**WELWYN HATFIELD BOROUGH COUNCIL
DIRECTORATE OF STRATEGY AND DEVELOPMENT**

DELEGATED APPLICATION

Application No: 6/2016/0616/FULL
Location: 2 De Havilland Close, Hatfield, AL10 0DR
Proposal: Conversion of existing single dwellinghouse into two dwellinghouses
Officer: Mr M Peacock

Recommendation: Granted

JOB/DRG. No:-
 2016-054C
 SHEET 2 OF 2

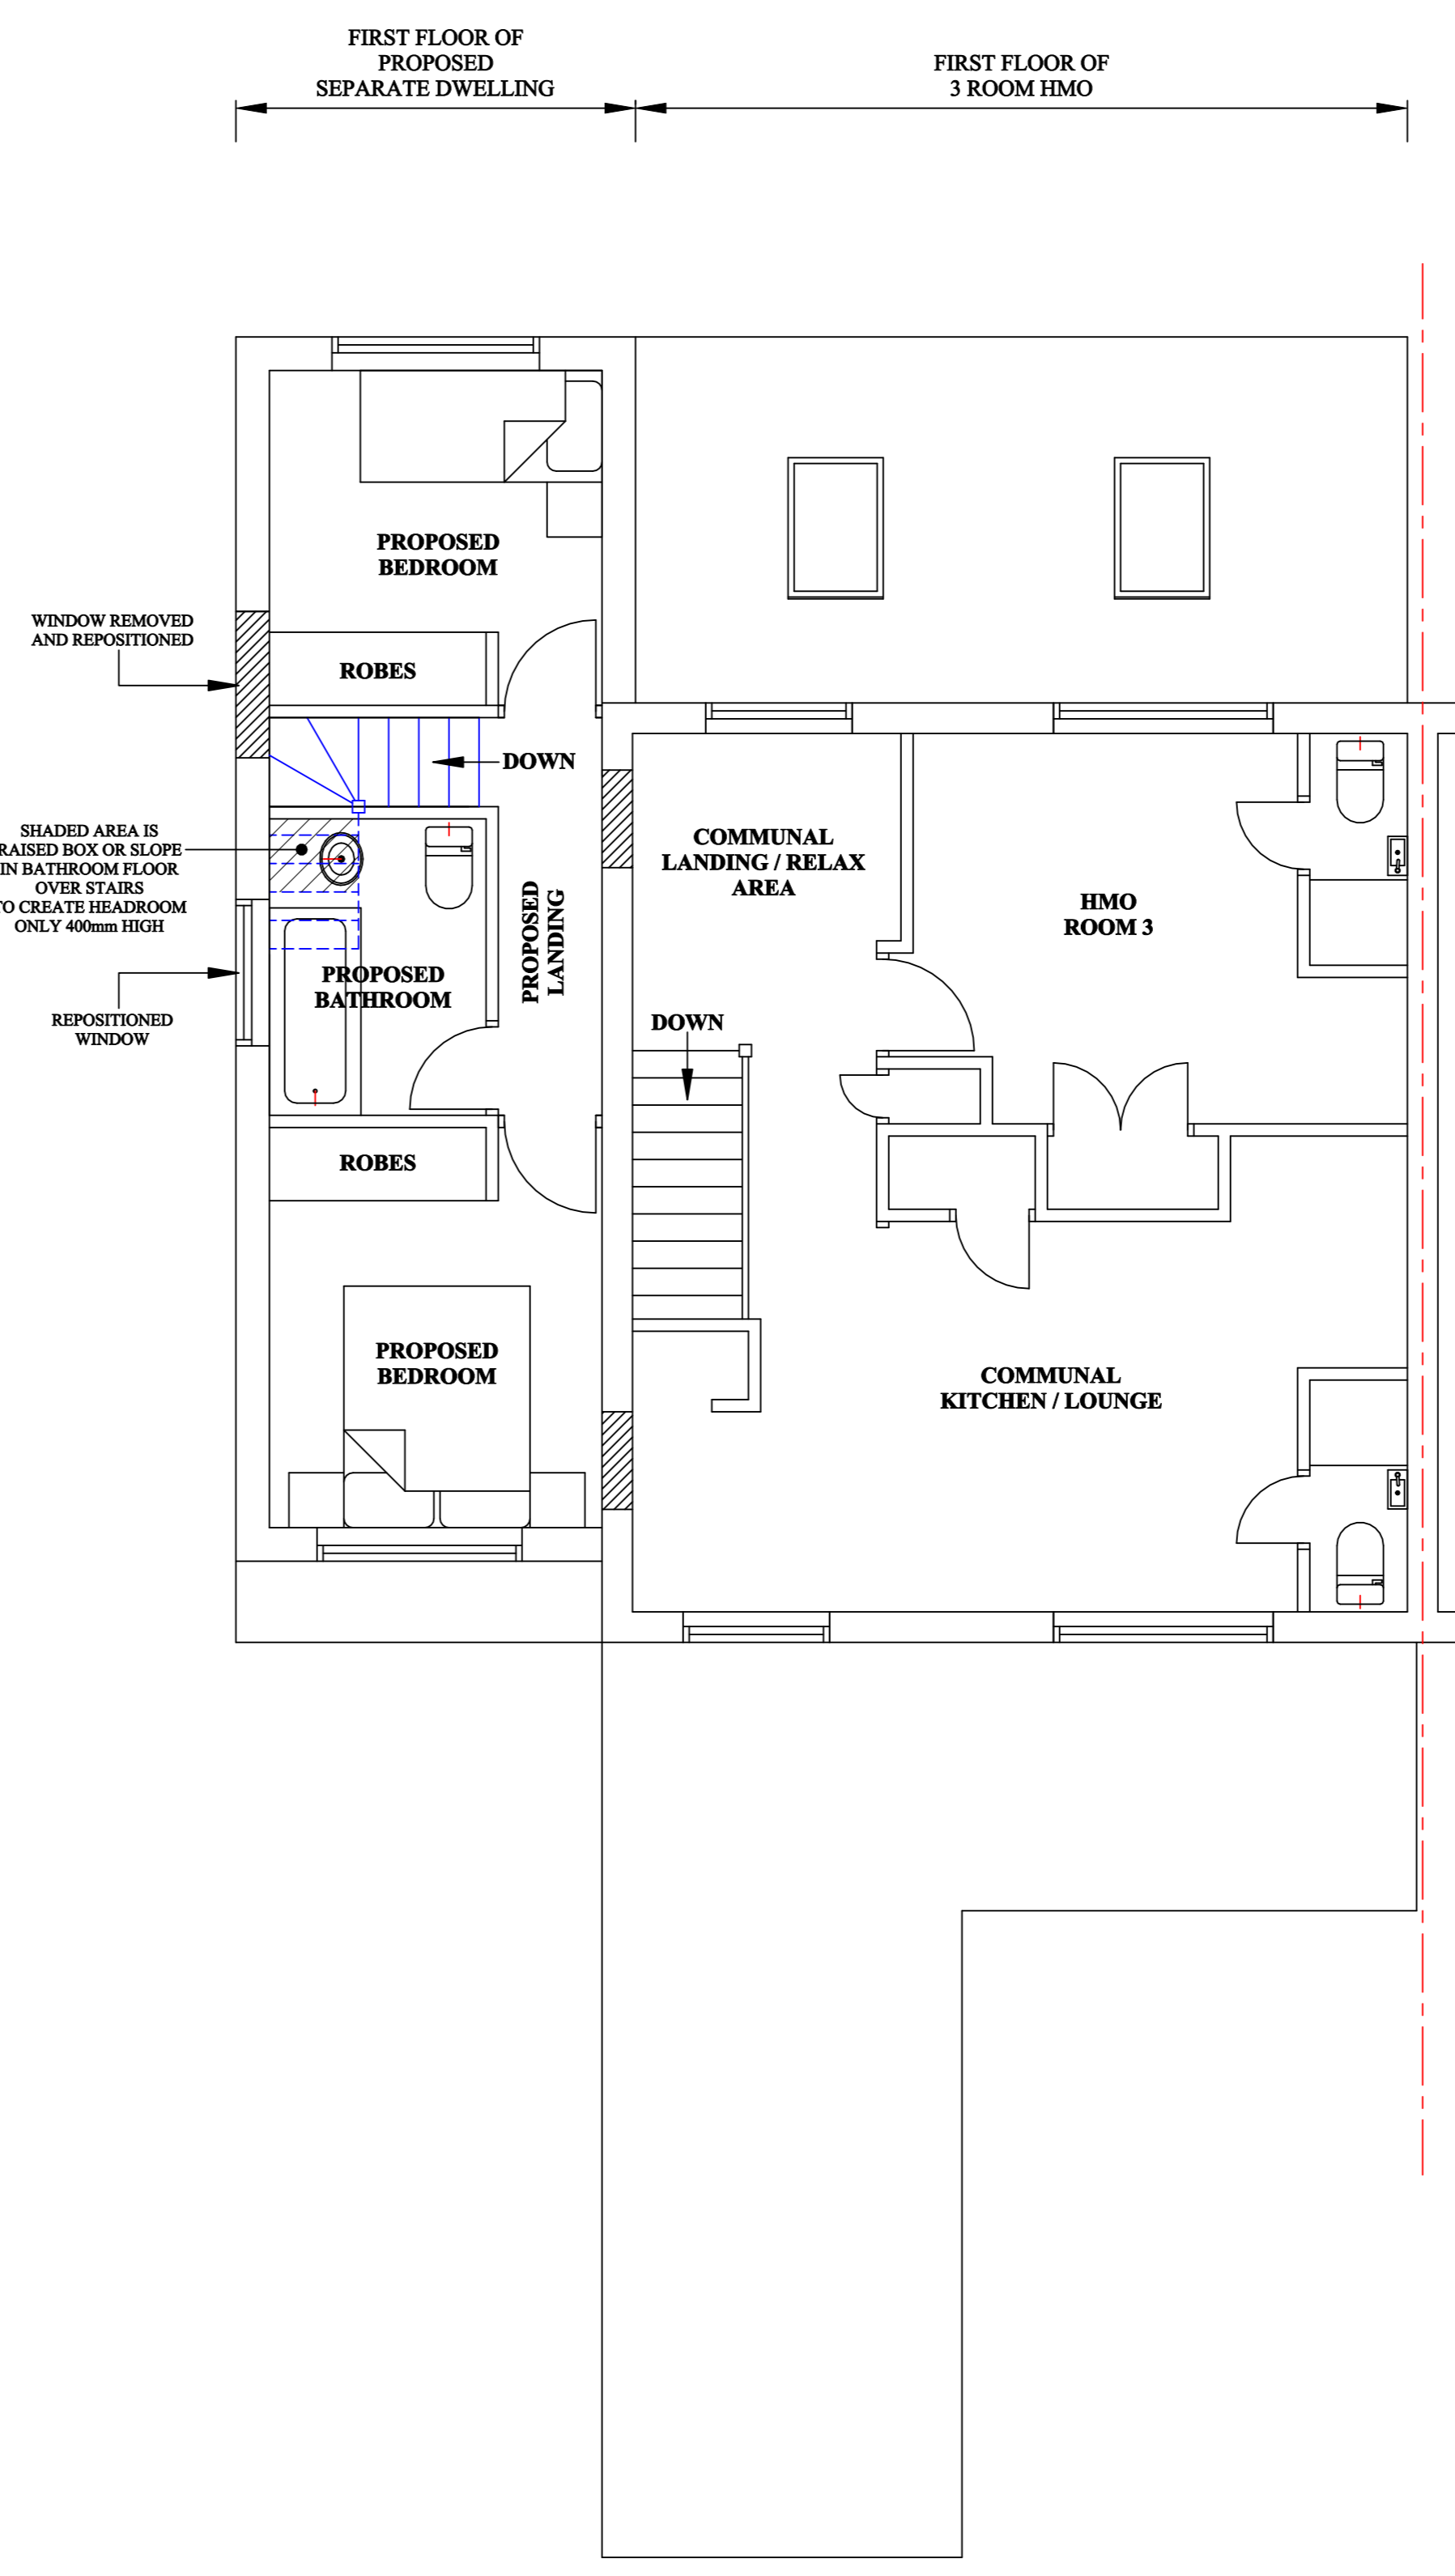
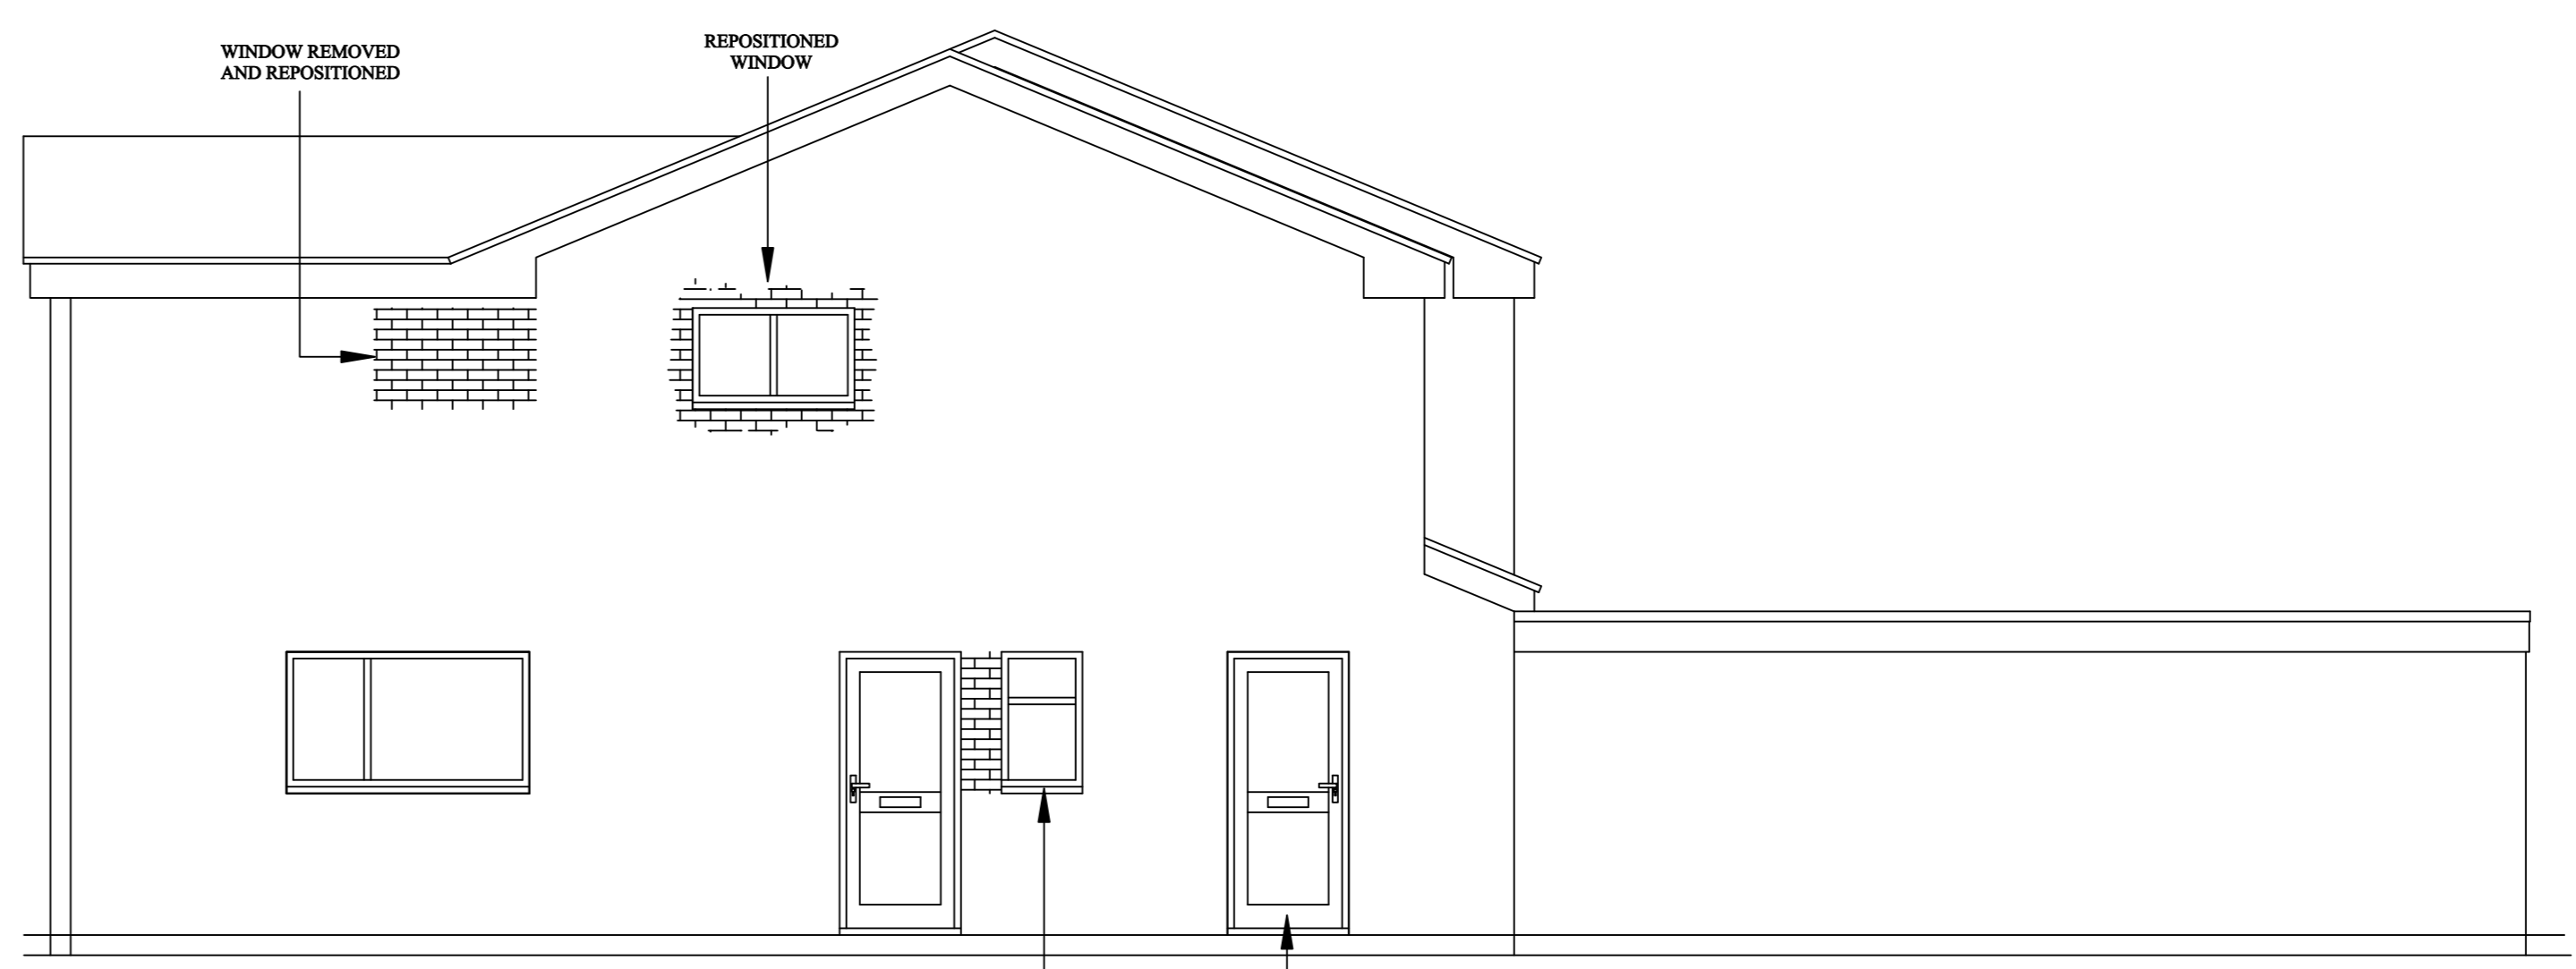
In terms of privacy, it is noted that the 2009 permission for the extension included a first floor window within the side elevation, which was shown to serve a bathroom on the approved drawings and was subject to a condition requiring fixed and obscure glazing. The current application proposes to relocate the bathroom window within the side elevation. Whilst it is likely that a bathroom window would be obscure glazed, for the avoidance of doubt and to prevent overlooking from an open window, it is reasonable to condition the relocated window to be to be obscure glazed and fixed below a height of 1.7m above the internal floor level.

5. The side of the proposed building shall be glazed with obscured glass and shall be fixed so as to be incapable of being opened below a height of 1.7 metres above floor level, and shall be retained in that form thereafter.

JOB/DRG. No:-  
2016-064C

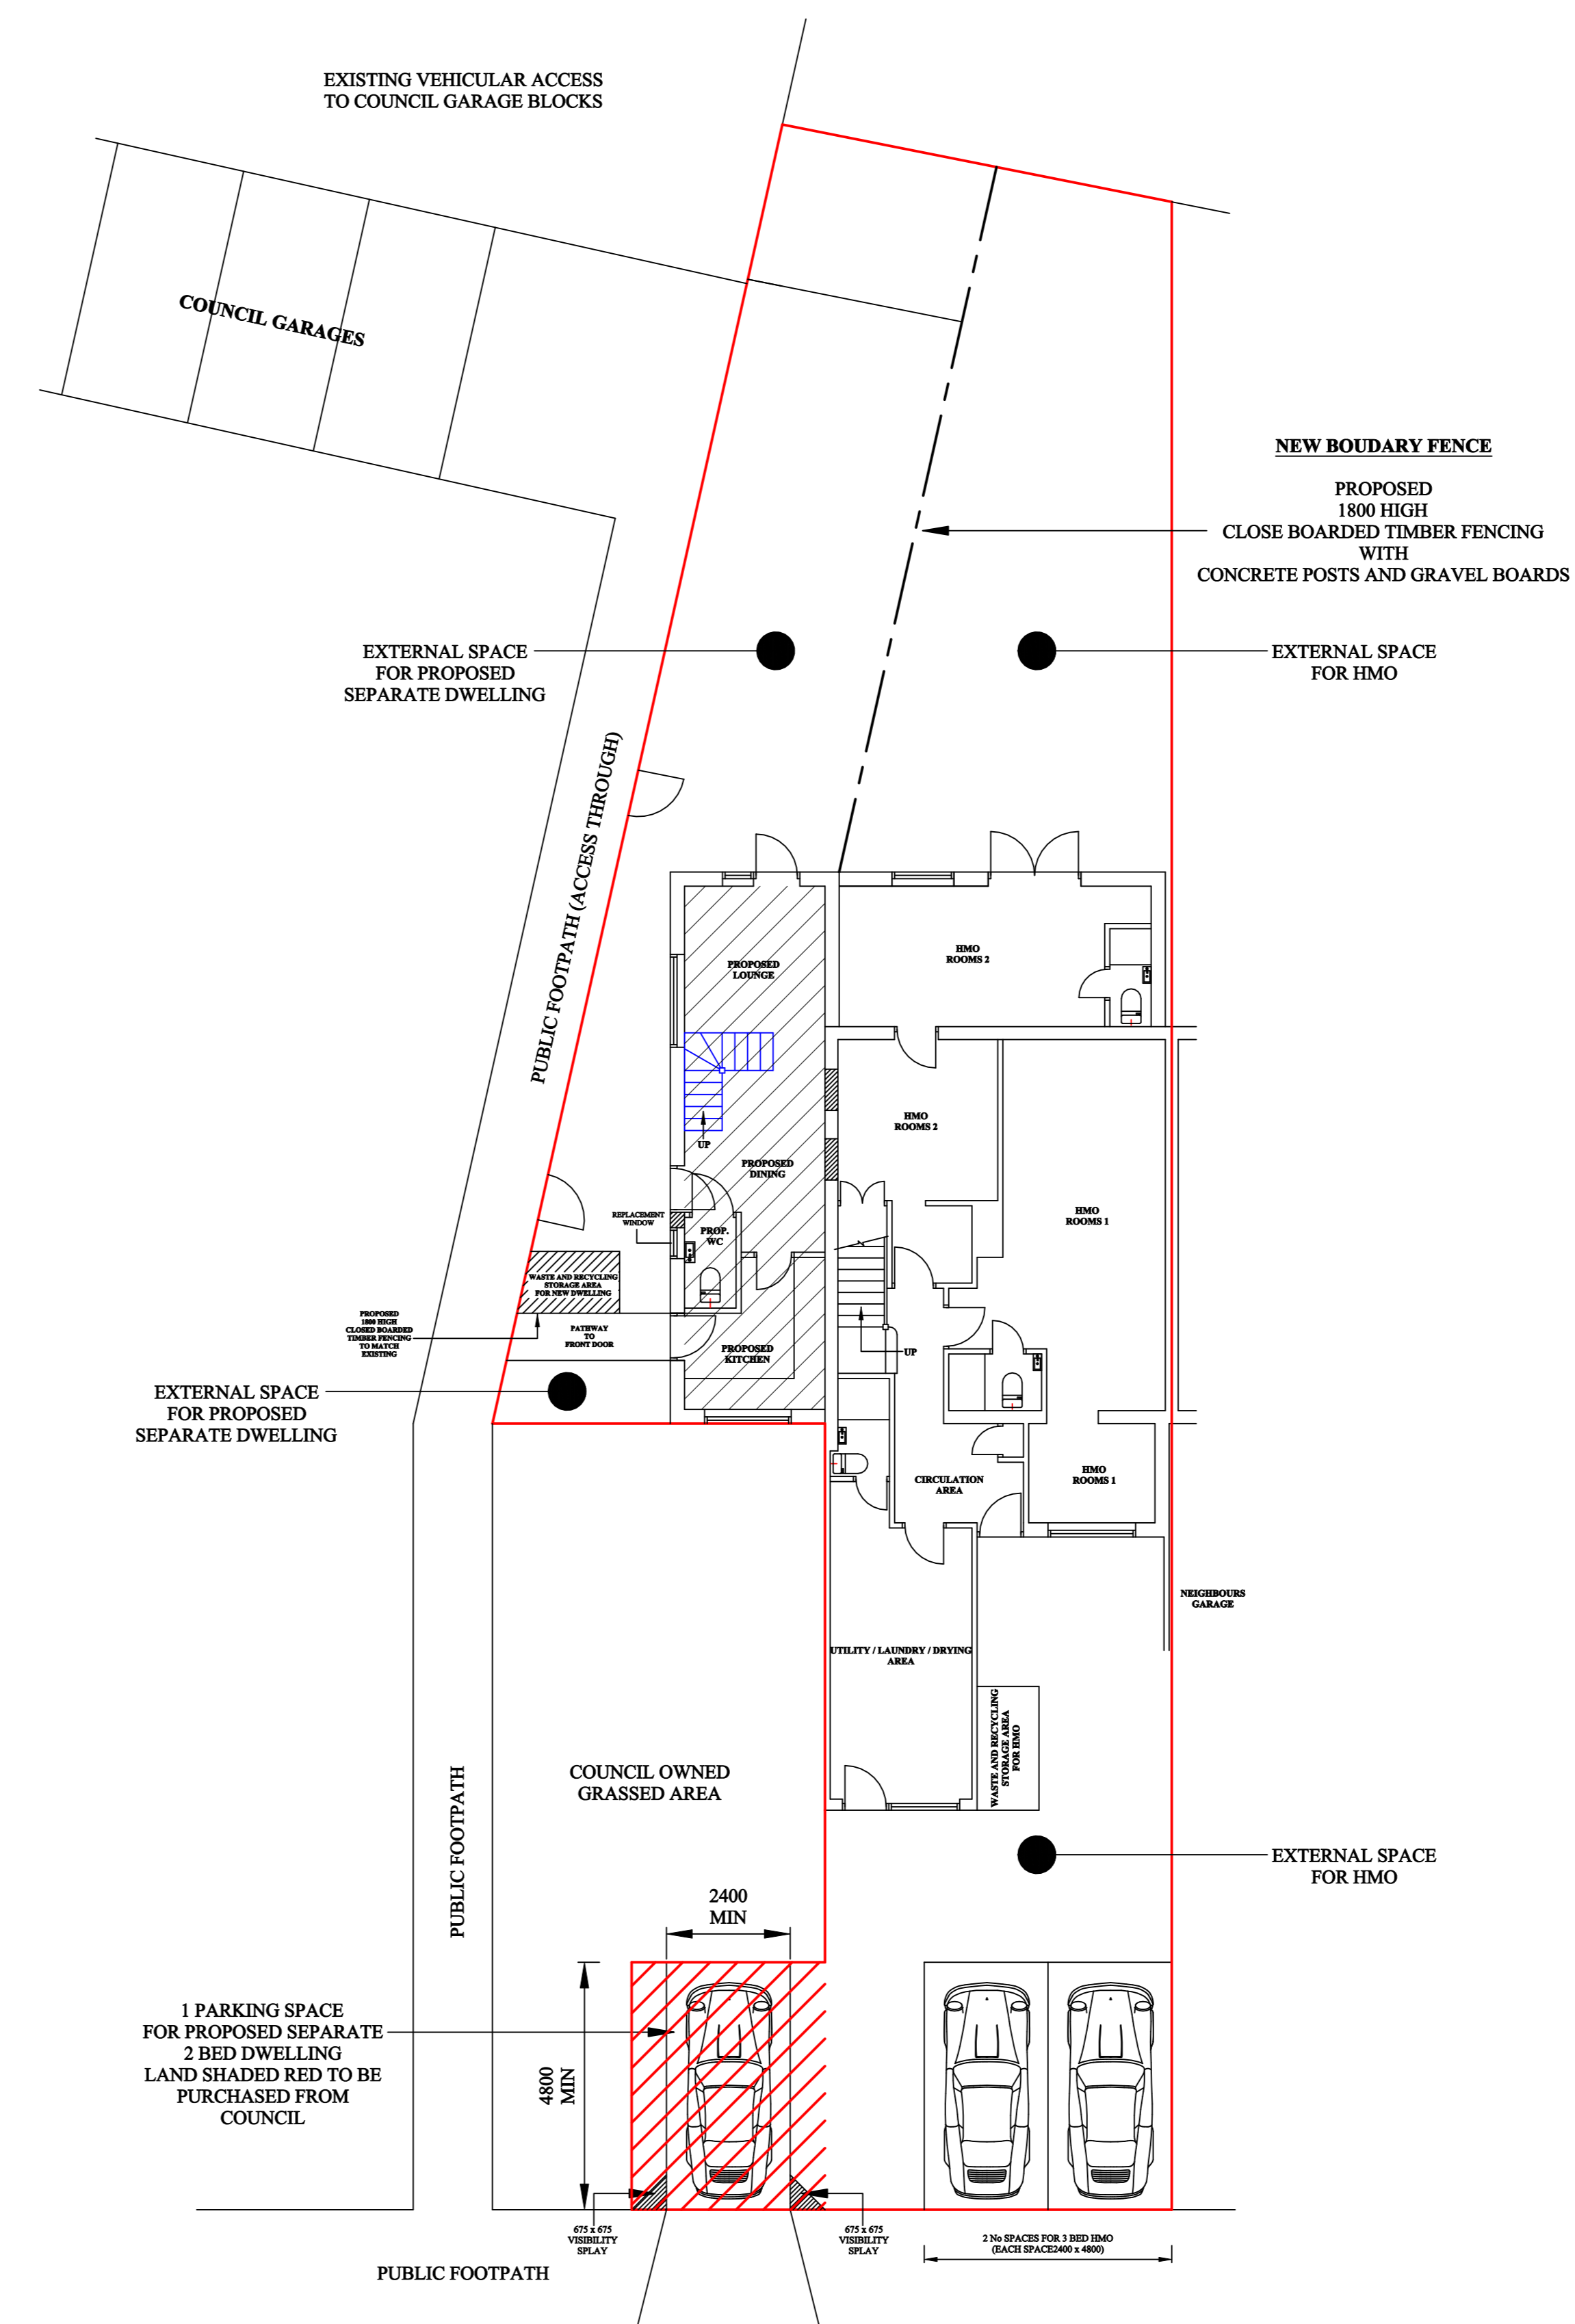
In terms of the comments made in respect of pollution and security, these relate to the parking space at the rear of the site as originally submitted. The amended proposal, whereby the parking space is provided at the front of the site, is considered to overcome these concerns. It is noted that no further objections/comments were received from residents following re-consultation in respect of the amended scheme.

Comment (if applicable): One additional off-street car parking spaces is proposed to the front of new dwelling which is acceptable for a two bedroom property in this location. The parking arrangements for the existing property are unaffected by the proposal.

Turning to highway safety, Hertfordshire County Council Transport, Programmes and Strategy have been consulted and consider that visibility from the proposed access would be acceptable and that the proposal is unlikely to have a material impact on the local and wider road network.

6. The area set aside for car parking shall be laid out surfaced and marked out, in accordance with a scheme which has been submitted to and agreed in writing by the Local Planning Authority before the buildings hereby permitted are first occupied and shall be retained permanently thereafter for the free parking of vehicles for residents/occupiers of the development permitted and shall not be used for any other purpose.
